OPW

O.P.W Ref No. 379-2024

Re: SID Planning Application No. 323780, The Proposed Windfarm within the townlands of Ballincurra, Ballinlee South, Ballinqayroure, Ballinbea, Knockuregare, Balinlee North, Carrigeen and Camas South, Bruff, Co. Limerick

ACP- PAX91.323780: Proposed Wind Farm Development in the townlands of Ballincurra, Ballingayrou, Ballinlee North & South, Ballinrea, Ballyreesode, Camas North & South, Carrigeen, Knockuregare, Ballybane and other townlands in County Limerick

Figure 2-22: Proposed Grid Connection Route

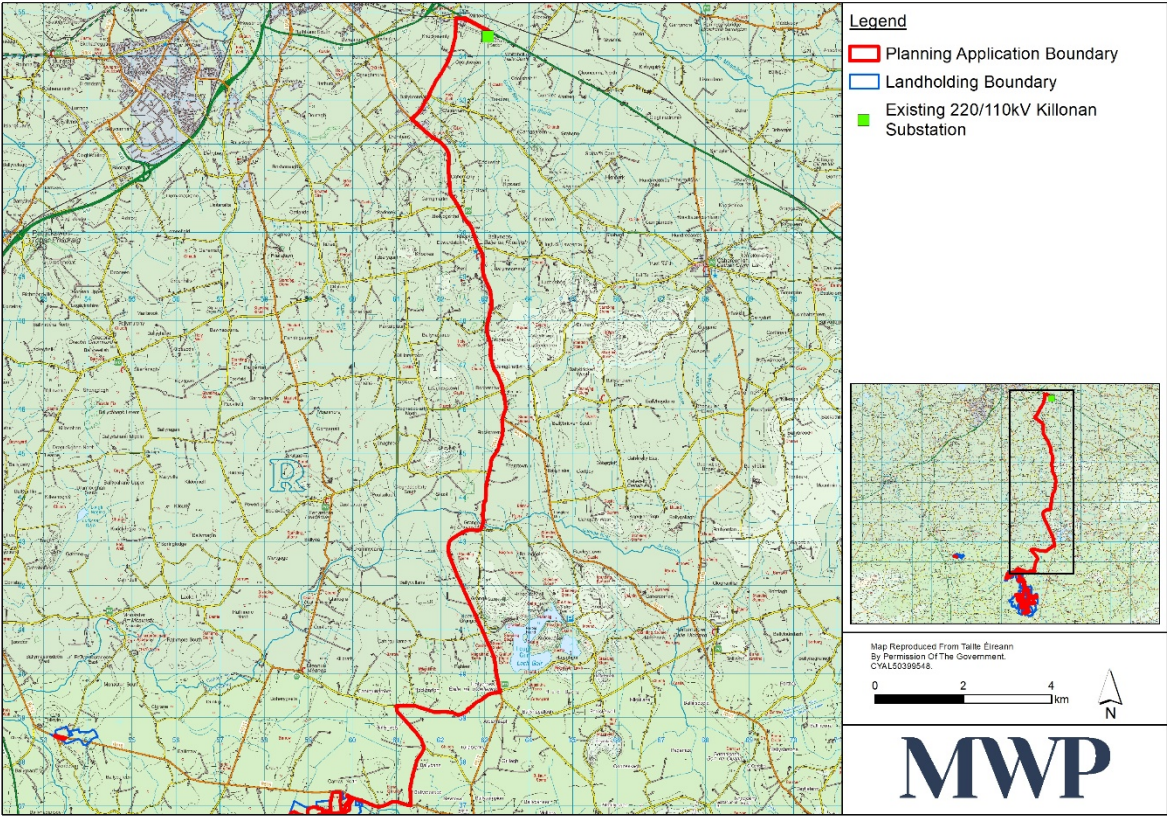
Regarding the proposed Internal wind farm underground power and communications cabling route indicated in your documentation but the location not provided, it is possible that this route may cross several watercourses. If the cable and ducting are to be buried in the road as they cross bridges over the water courses, and there is no interference with the opening in the bridge spanning the watercourse, then there is no issue. On the other hand, if it is proposed to pass the cable in its ducting through the opening of any bridge or culvert, this would be considered to be a modification of a bridge, and it would require the consent of the Commissioners under Section 50 as mentioned above. Similarly, if it is proposed to carry the cable in its ducting across watercourses on new support structures spanning the watercourses, these should be treated as if they are bridges, and the consent of the commissioners under Section 50 should be obtained. If the cable and ducting are to be buried under the natural bed of the watercourses being crossed, Section 50 would not apply, and we would recommend that the duct be buried a sufficient distance below the natural bed to allow for erosion and mobility of the stream bed.

The OPW notes the concerns of the DAU of the DHLGH. The OPW questions why the applicants have chosen a route for the underground cable that passes through the Lough Gur zone, with its very high possibility of archaeological finds and disruption.

Figure 12-4: Excerpt from Limerick DP Scenic Views and Prospects Map

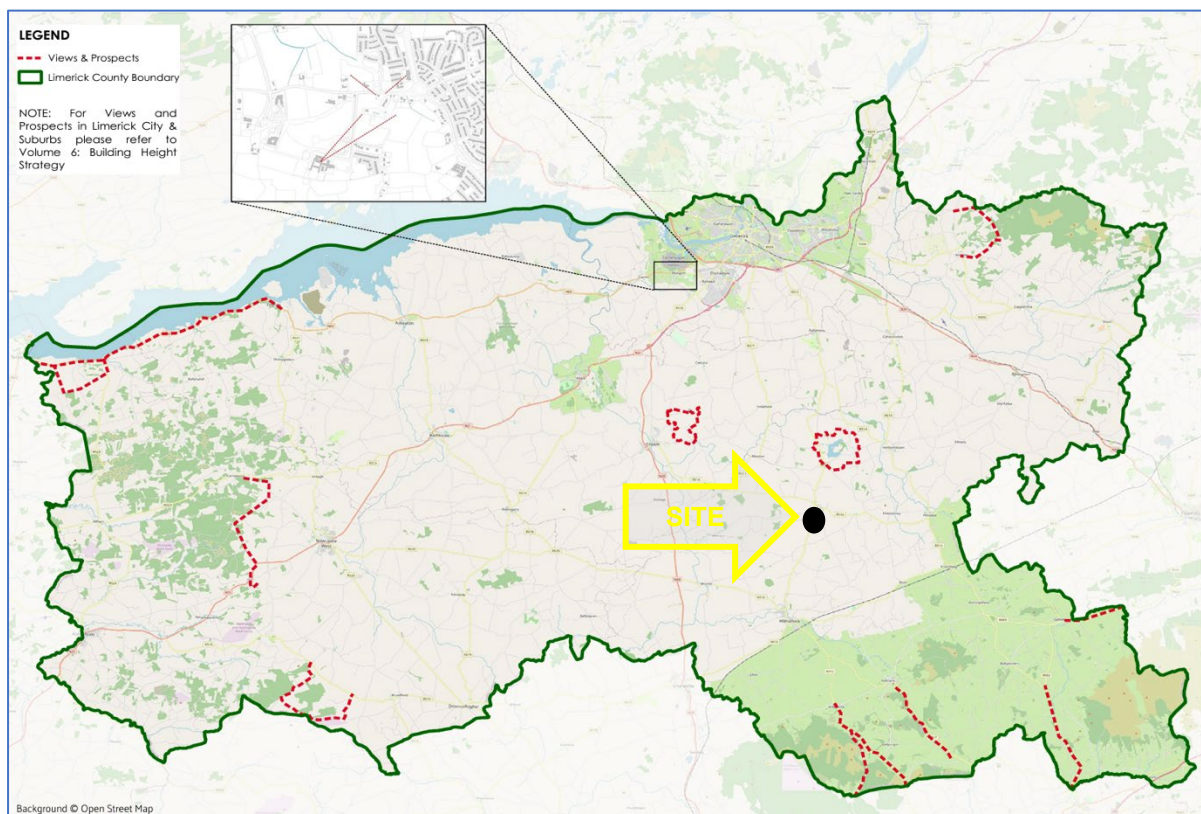
Lough Gur is identified in the *Limerick County Development Plan 2022-2028* for protection of Views and Prospects (see Fig 1 below).

The OPW is very concerned about the visual and cultural impact of the proposed Ballinlee Windfarm from this view and the cumulative impact with Garrane windfarm. The OPW urges ACP to require the application to produce a photomontage from this location, for Ballinlee WF alone and as a cumulative impact assessment.

Figure 12-6: Zone of Theoretical Visibility Map (ZTV) – Tip Height

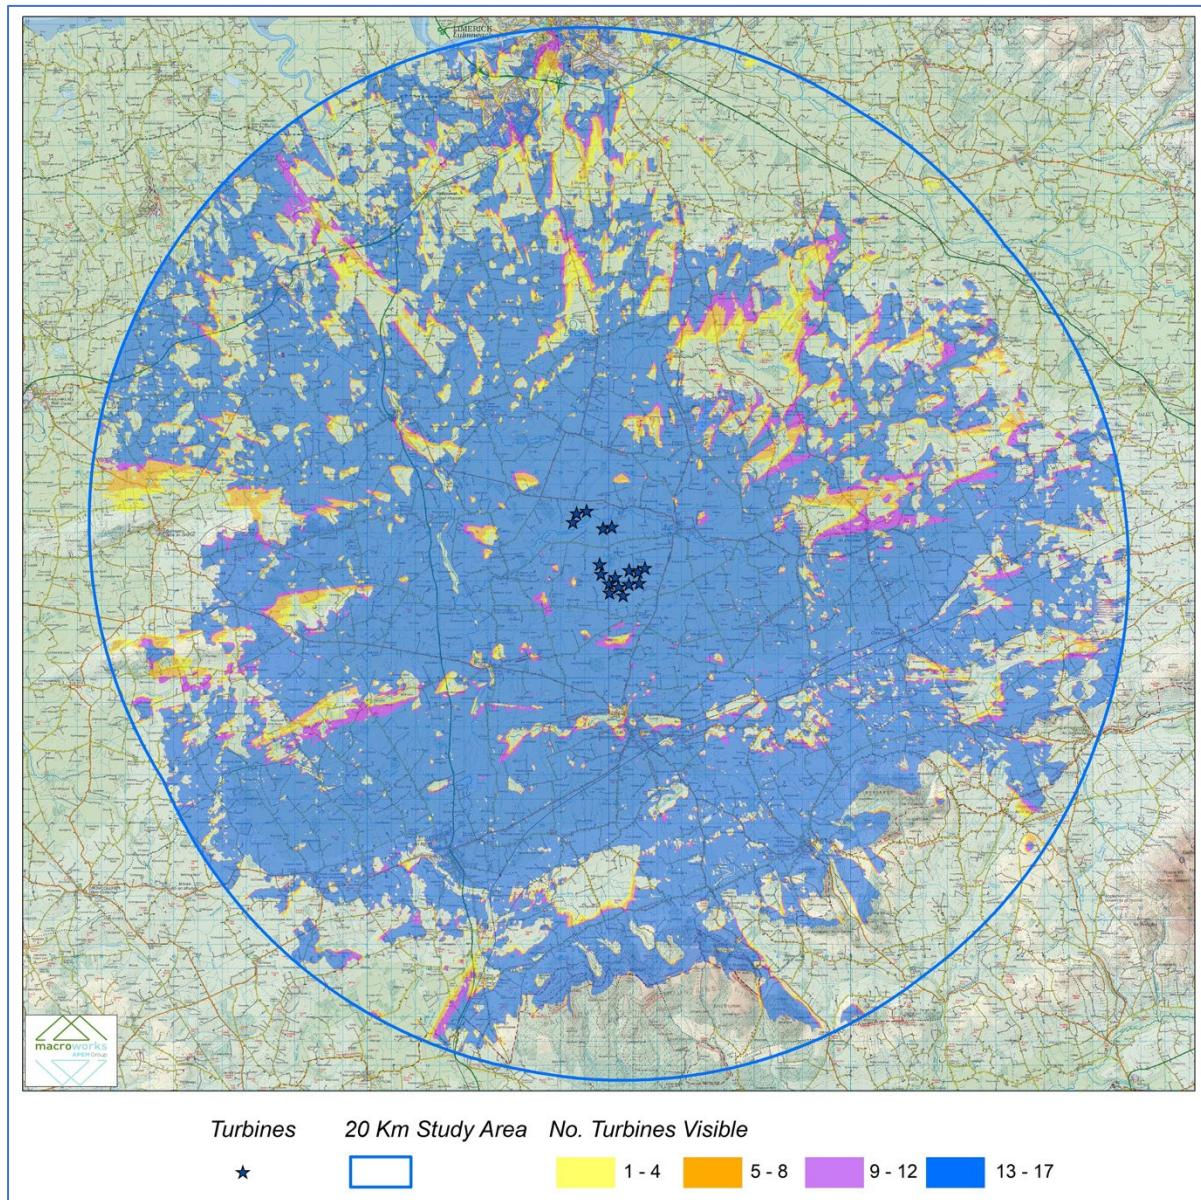
Fig. 3 Extract from ZTV mapping for cumulative impact, with Lough Gur and Knockainey highlighted by the OPW
